Town & Country Planning Act 1990 (as amended)
Town & Country Planning (Tree Preservation) (England) Regulations 2012
Application for Works to Tree(s) on trees subject to a Tree Preservation Order (TPO)

Development Reduce laterals on northside away from property by 2-3m to 1 No. Field Maple tree.
Reduce 2 tops height by 6m and remainder limbs to match and deadwood 1 No. Oak tree.

Location Strawberry Cottage Cypress Way Aldwick

REF 1

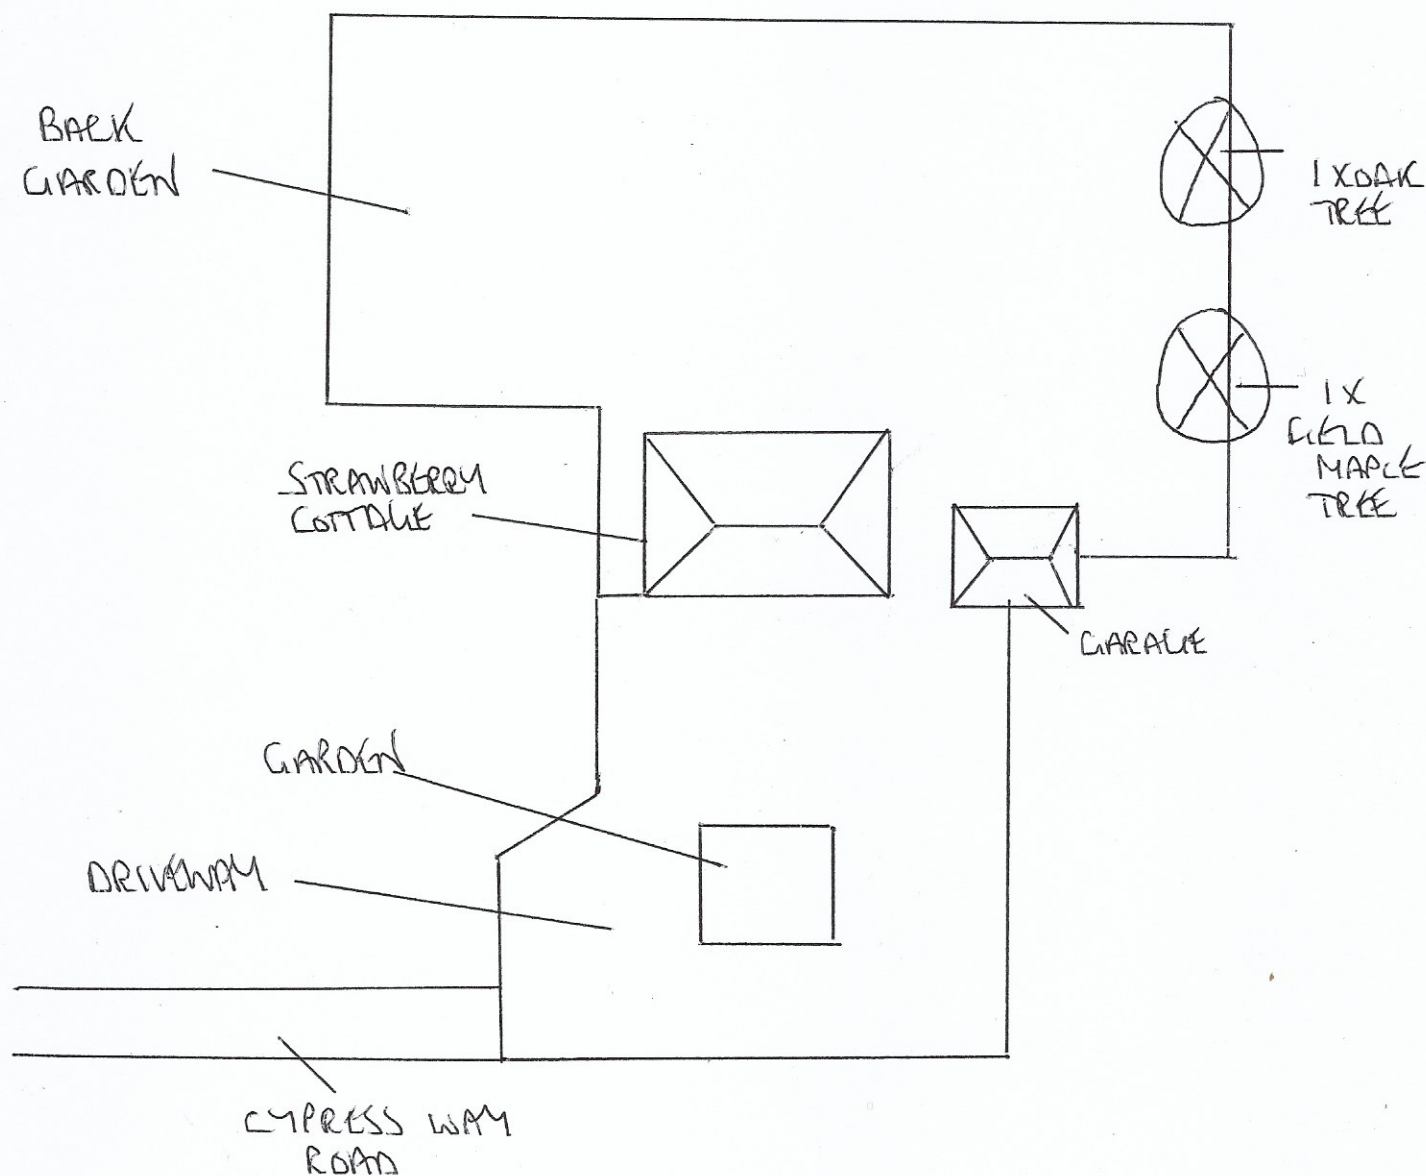
1 No. Oak tree - please confirm how much remaining limbs are to be reduced by.
